From: Scott O'Neil [sonell@proconinc.com]
 Sent: Thursday, May 03, 2007 10:22 AM
 To: Larry Ross
 Cc: Randy Allred; Craig Hill; Matt Labonte
 Subject: RE: Roof sketch
 Follow Up Flag: Follow up
 Flag Status: Red

CUSTOM HOUSE SQUARE
 300 FORE STREET
 PORTLAND, MAINE
 WALL SECTIONS

A4.13

A4.13

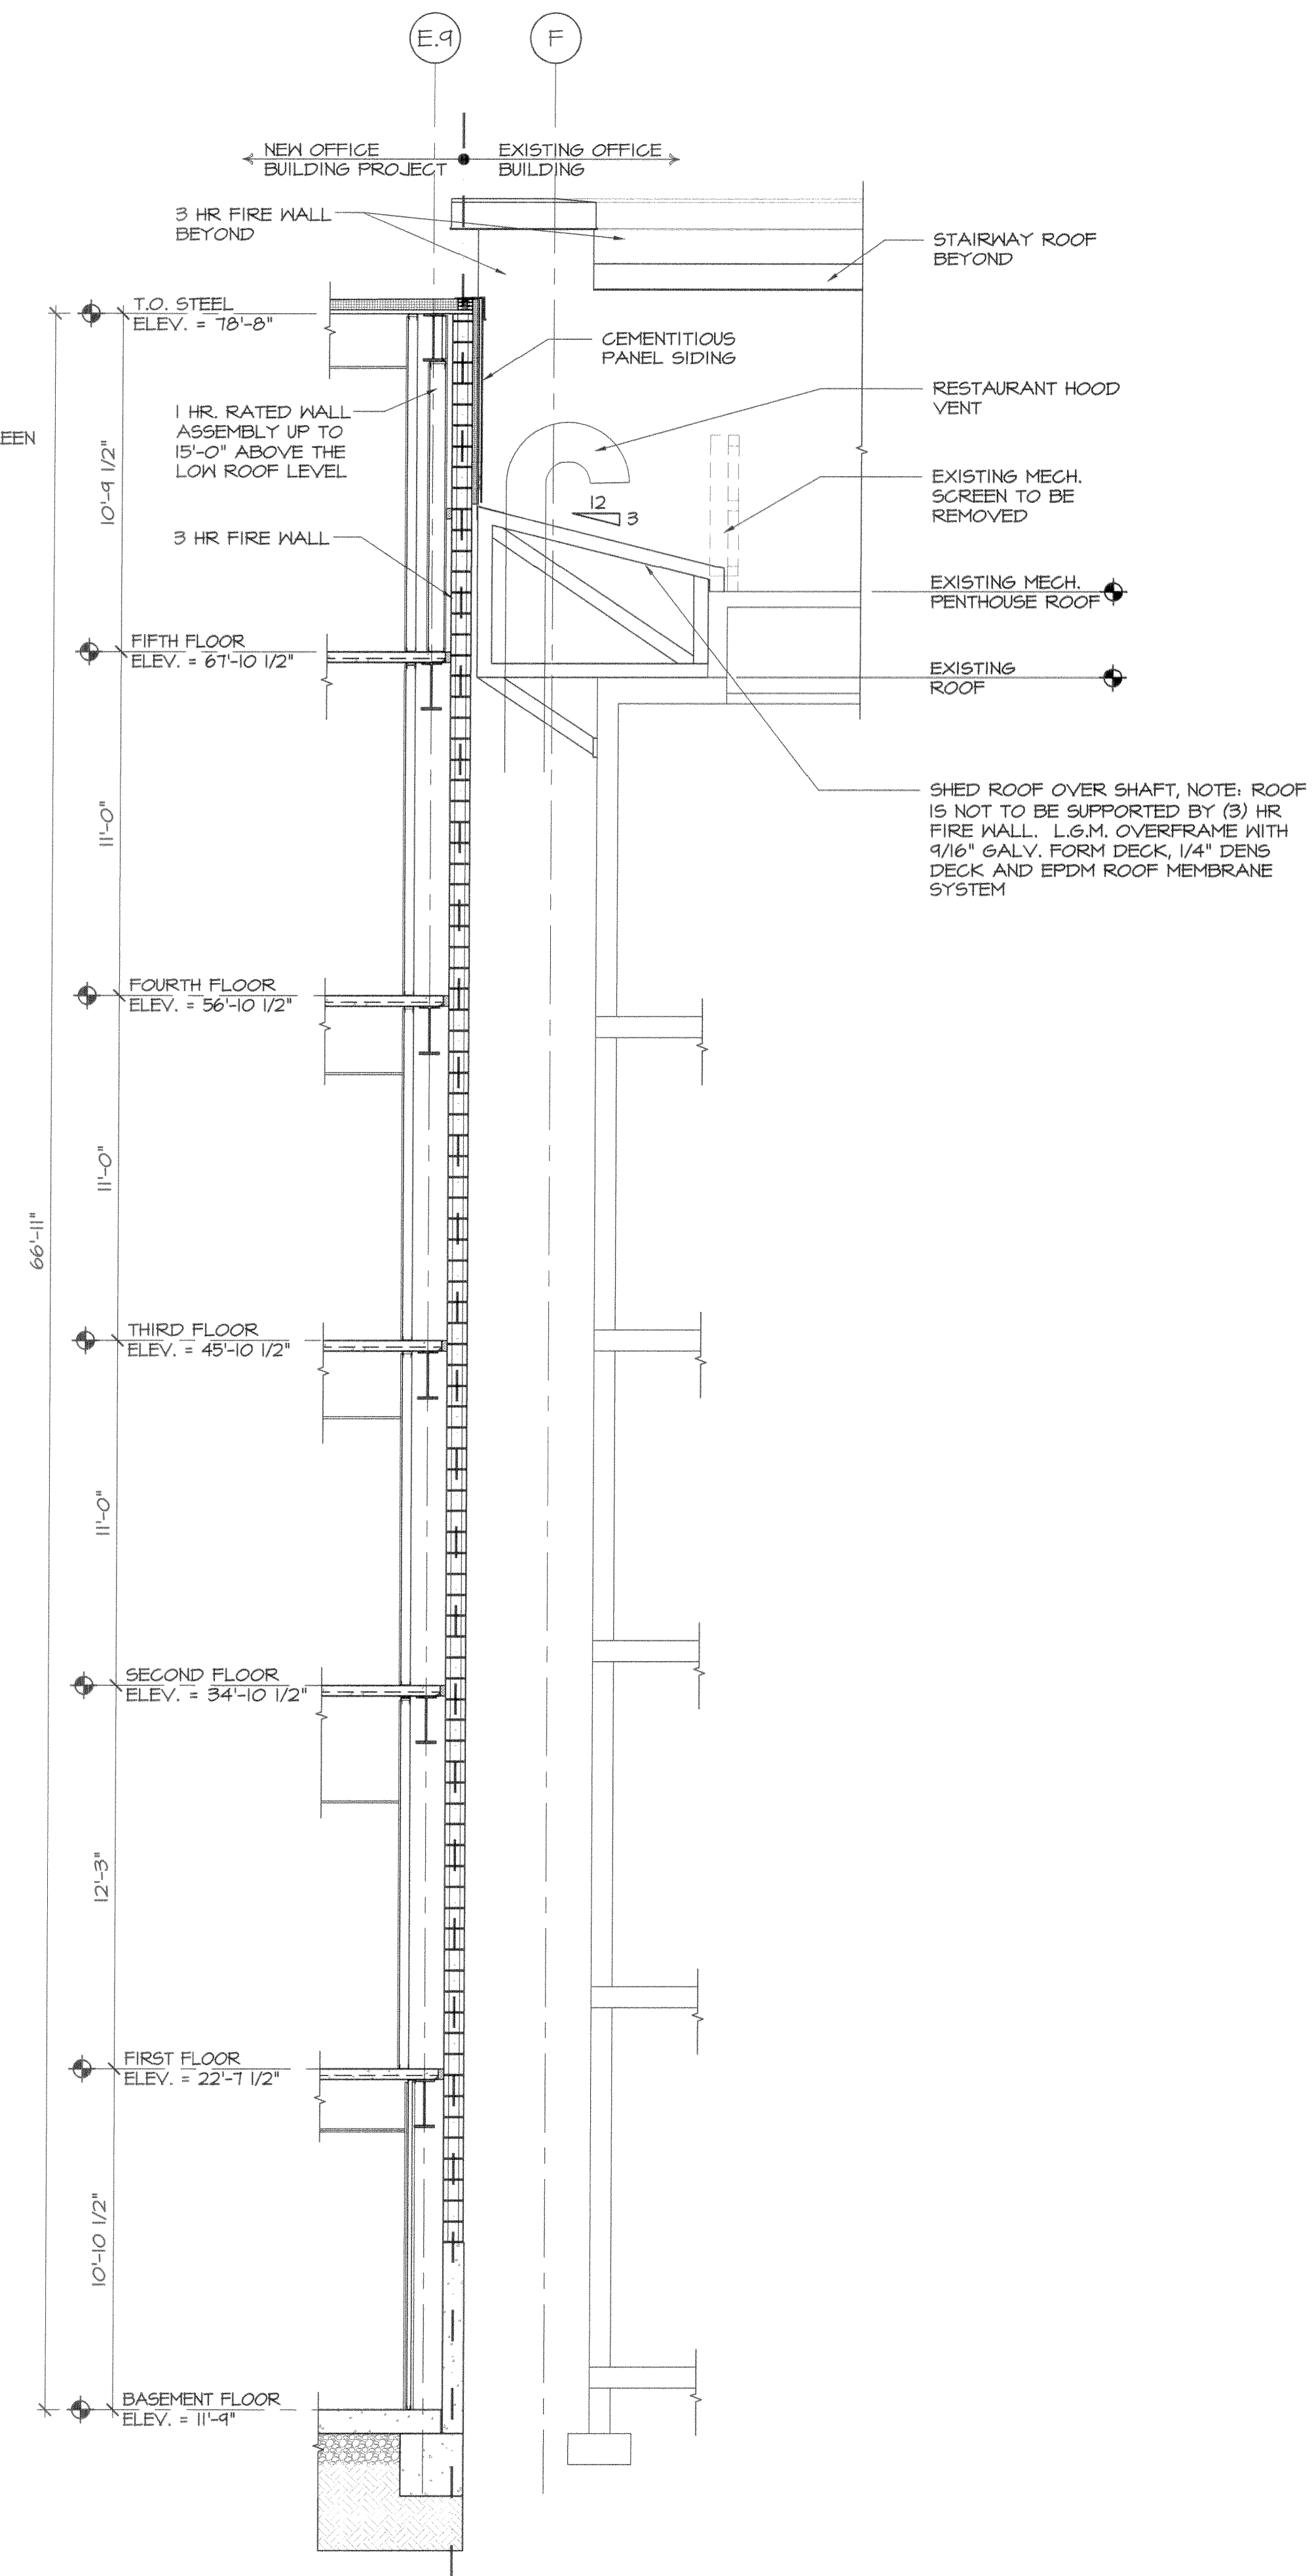
We have reviewed your sketch for the roof over the mechanical shaft and take no exceptions to your proposal. We do want you to add a metal stud kicker back to the 2 hour CMU shaft wall at every other stud for support.
